NSW Department of Planning & Environment
Industry Assessments
4 Parramatta Square
12 Darcy Street
Parramatta NSW 2150

Tuesday, 29 March 2022

Integrated Water Cycle Management Review of Aspect Industrial Estate SSDA in the Mamre Road Precinct

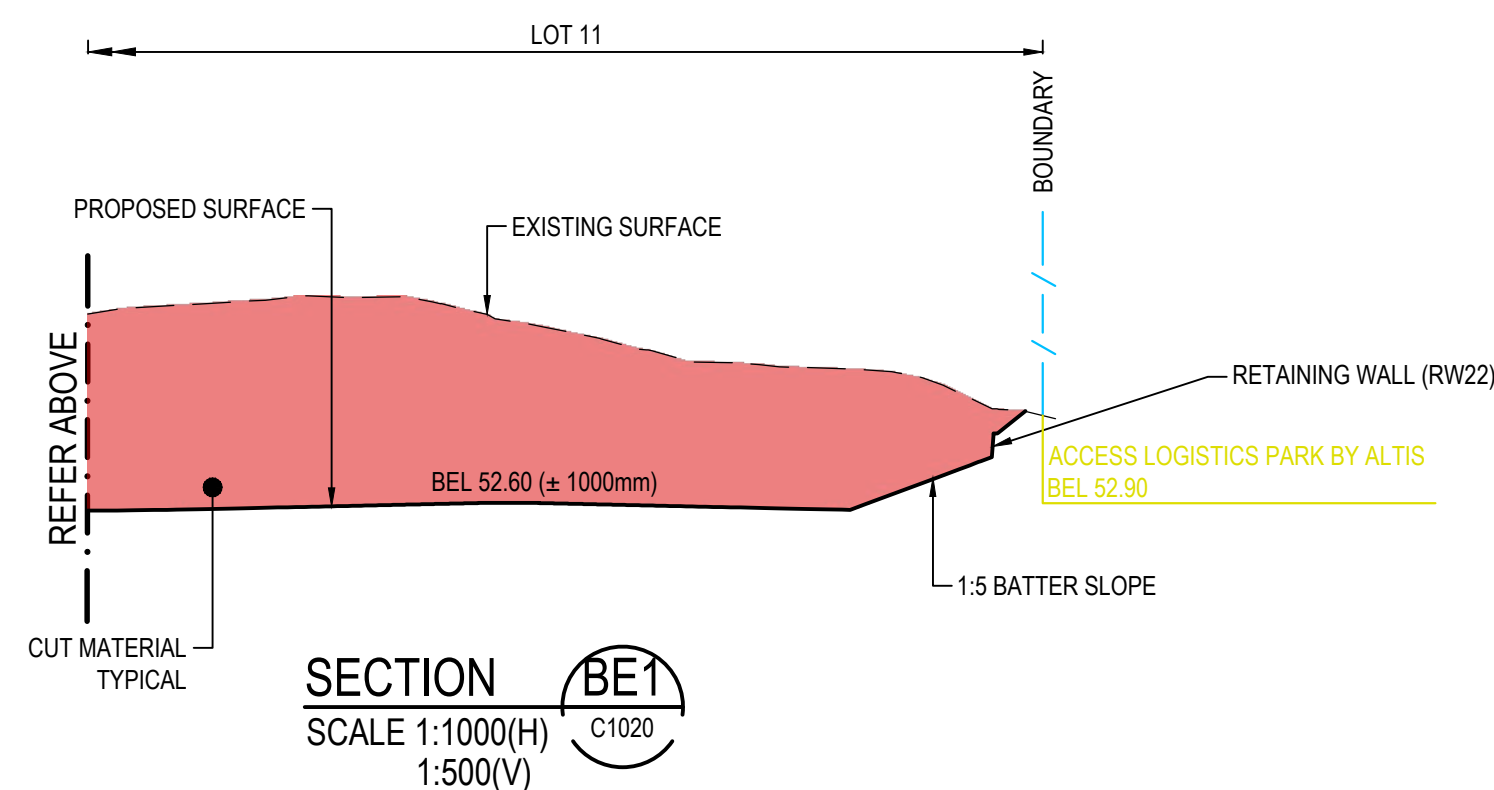
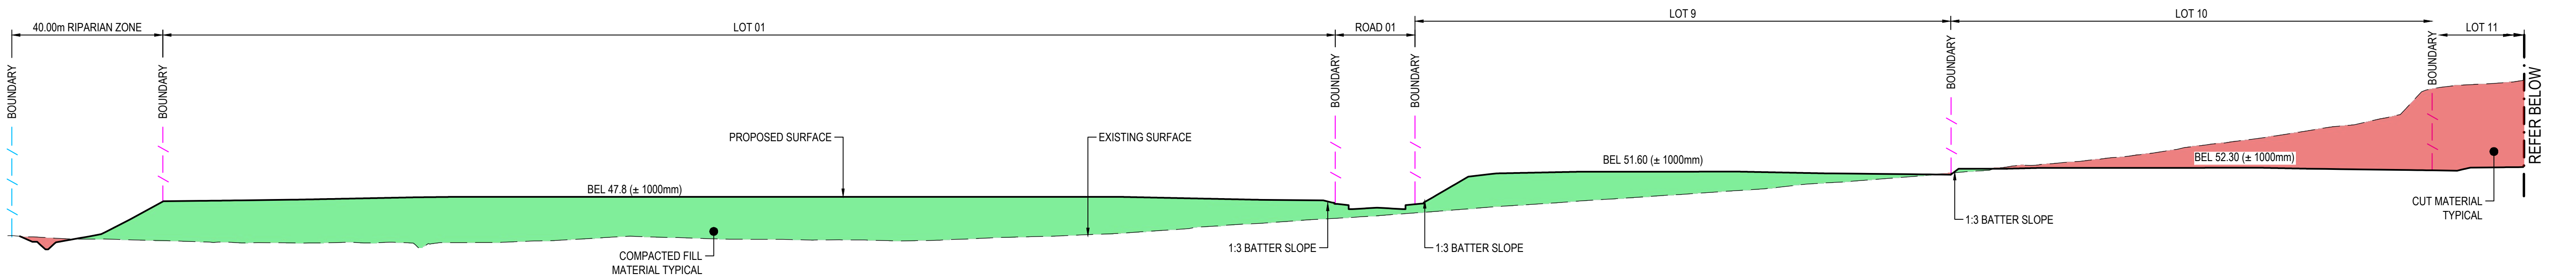
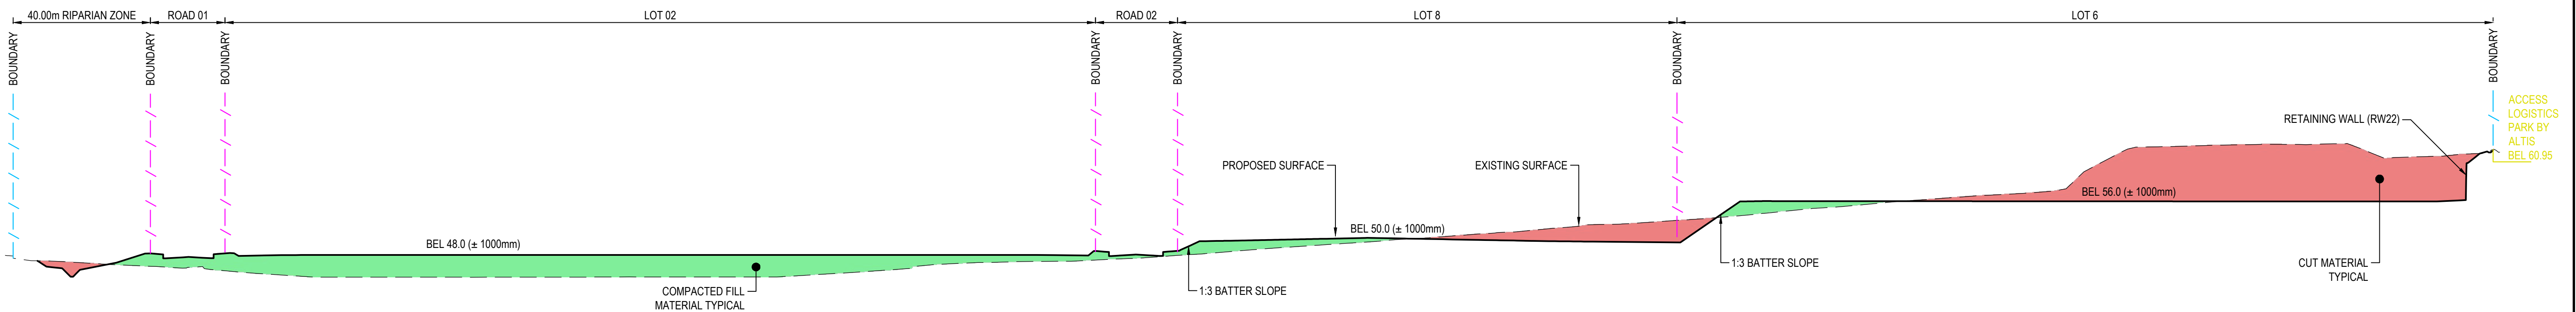
17)	High vertical walls and steep batters shall be avoided. Batters shall be vegetated with a maximum batter slope 1V:4H. Where unavoidable, retaining walls shall not exceed 2.0m in cumulative height.	Yes	Batter slopes on the revised civil plans are noted as 1:4 (temp) and 1:5 (permanent) UNO. Without specific notations on the slopes we have interpreted these to be 1:5 batter slopes. A retaining wall is proposed to the lot interface with the channel in the vicinity of the proposed basin. This is deemed acceptable.

OPTON 1 - CONFIG#26 SWAMP FOREST INFILTRATION TO DEEP SOIL

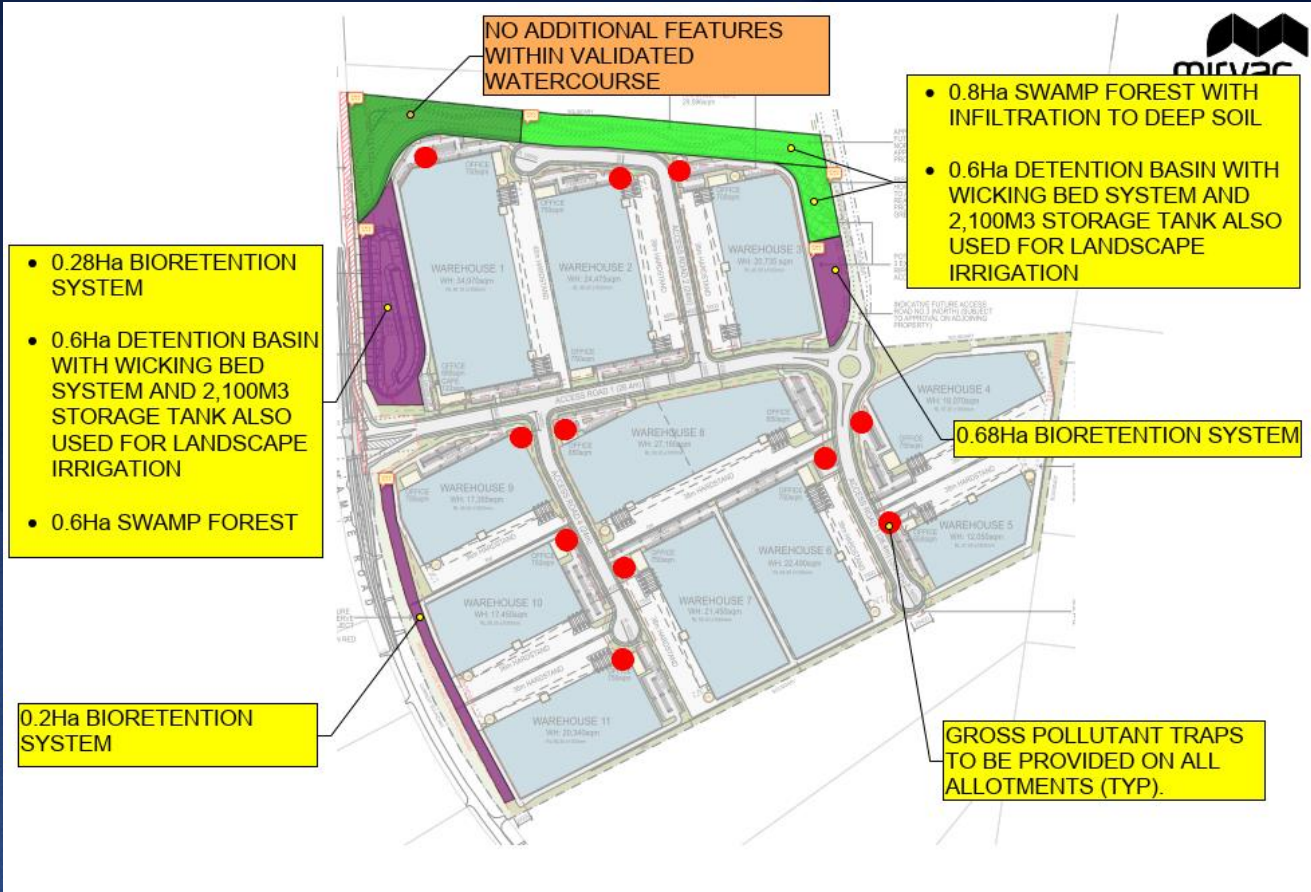
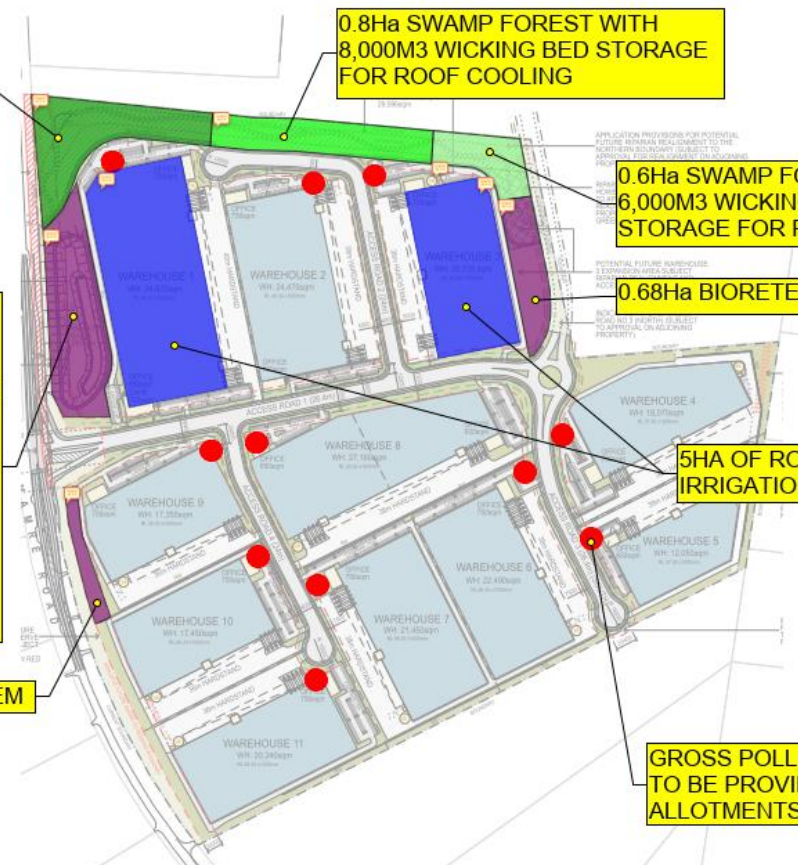
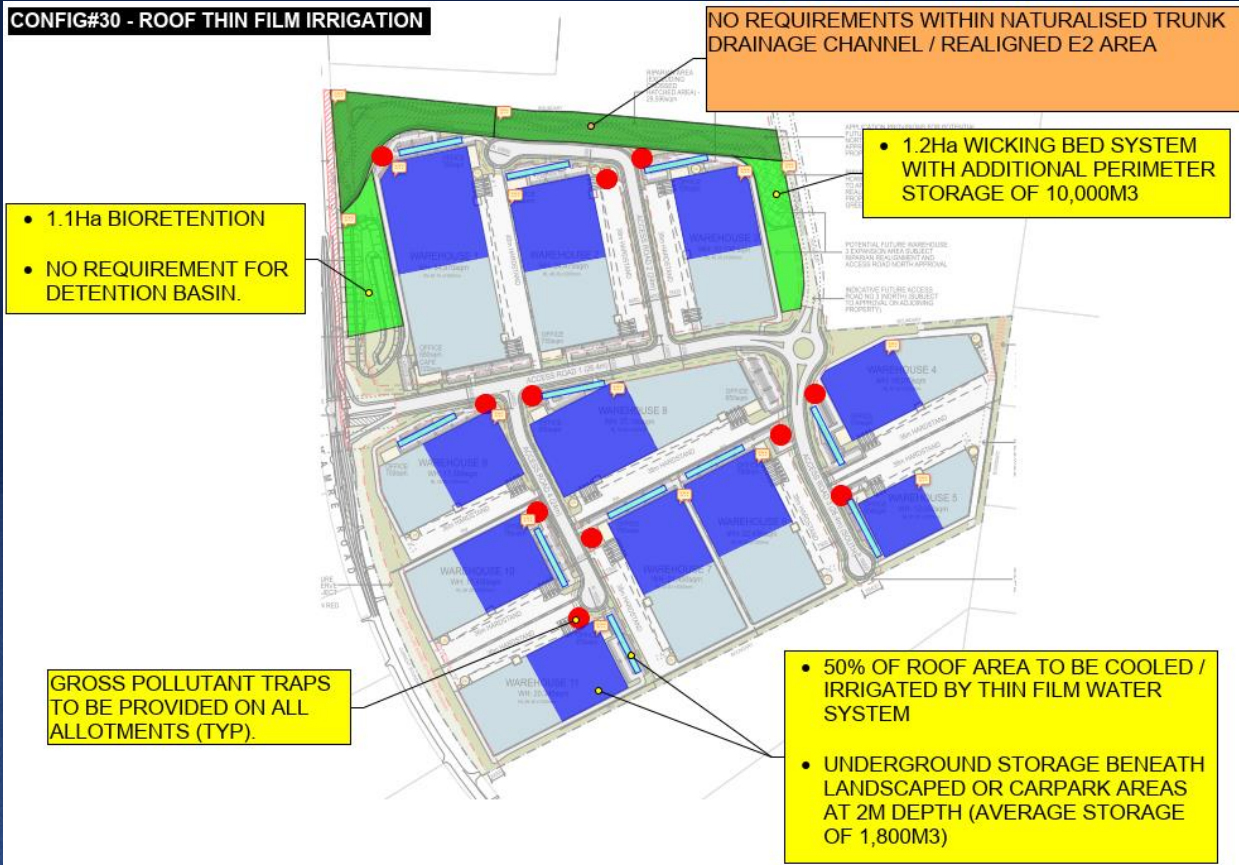
The DCP is clear that any infiltration of stormwater into the soil profile will not be accepted, unless the proposal includes a salinity and sodicity assessment of the soil. This has not been sighted and therefore any option including infiltration of stormwater cannot be accepted.

Some of the landscape irrigation areas in the MUSIC model do not appear to correlate with the re-use demands. Also, they are not presented on a plan that demonstrates that the necessary landscaped areas are available for irrigation.

The roof irrigation rate of 19.1ML/Ha/yr does not take rainfall into account and only includes PET. This should be changed to PET – Rain to ensure that roof irrigation is not occurring during rainfall events and overestimating the amount of water “lost” from the system.

Recommendation 2: *That the proponent prepare a salinity/sodicity assessment of the soil demonstrating that the existing soil profile is capable of receiving infiltration safely, or that all infiltration be removed from the proposed treatment train and MUSIC modelling.*

Recommendation 3: *MUSIC model is checked and irrigation areas aligned with re-use numbers. Additionally, that a site plan is prepared illustrating that sufficient areas are available on site for the landscape irrigation proposed in the MUSIC model.*

Recommendation 5: *That roof misting/irrigation rate needs to be updated, re-modelled and resubmitted for approval to ensure that no irrigation is occurring during rainfall events.*
